Millers Point Community Resident Action Group

Thursday 20 May 2021

Re: Significant Development: Fort Street Public School Application No SSD-10340 – Mod 1
Submission from Millers Point Community Resident Action Group

title
General Arrangement Plans
Proposed Plan - Level 3

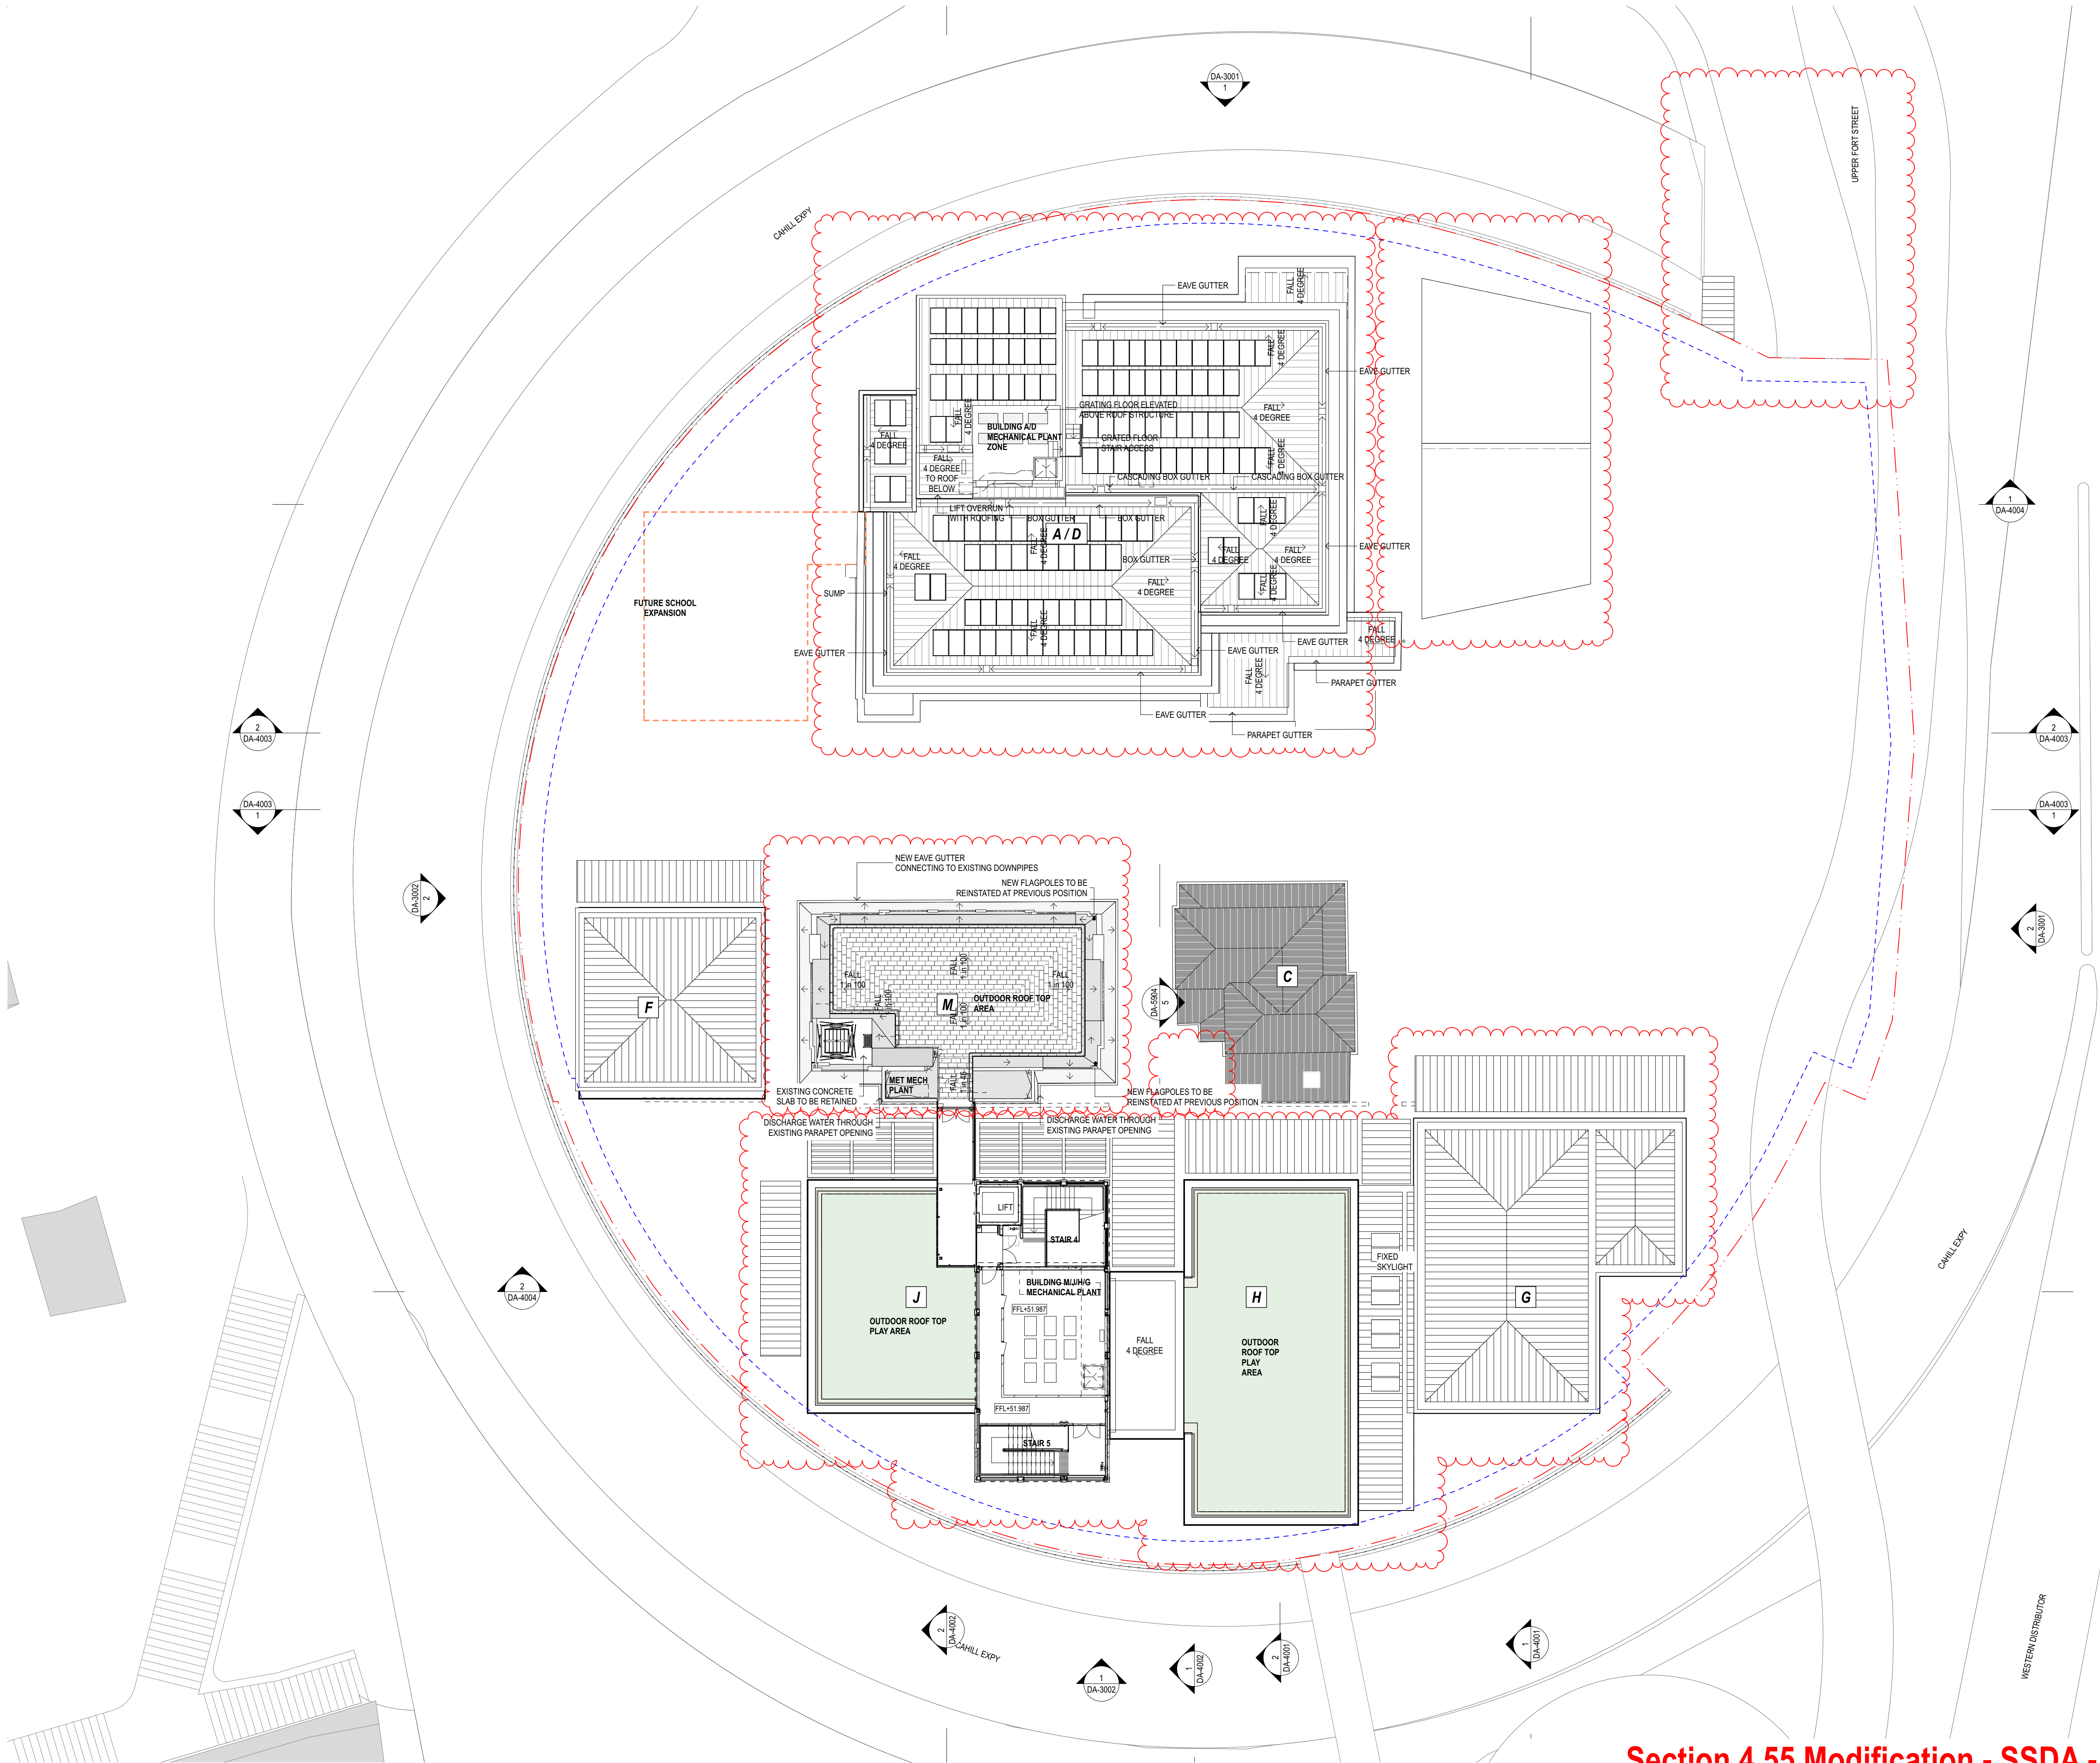
Overdevelopment of the site (Building J) decreases the “openness” of the school. In particular, the large four storey fire escape stair dominates the northern prospect from the National Trust building. It also sets an alarming precedent for building heights.

- The proposal has not been assessed in accordance with the existing Conservation Management Plan (Curio Projects, March 2020). The CMP stated that the Bureau of Meteorology building should remain the dominant building on the site.
- The addition of an extra floor above the height plan of the Meteorology Building contravenes previous heritage recommendations, including the CMP.
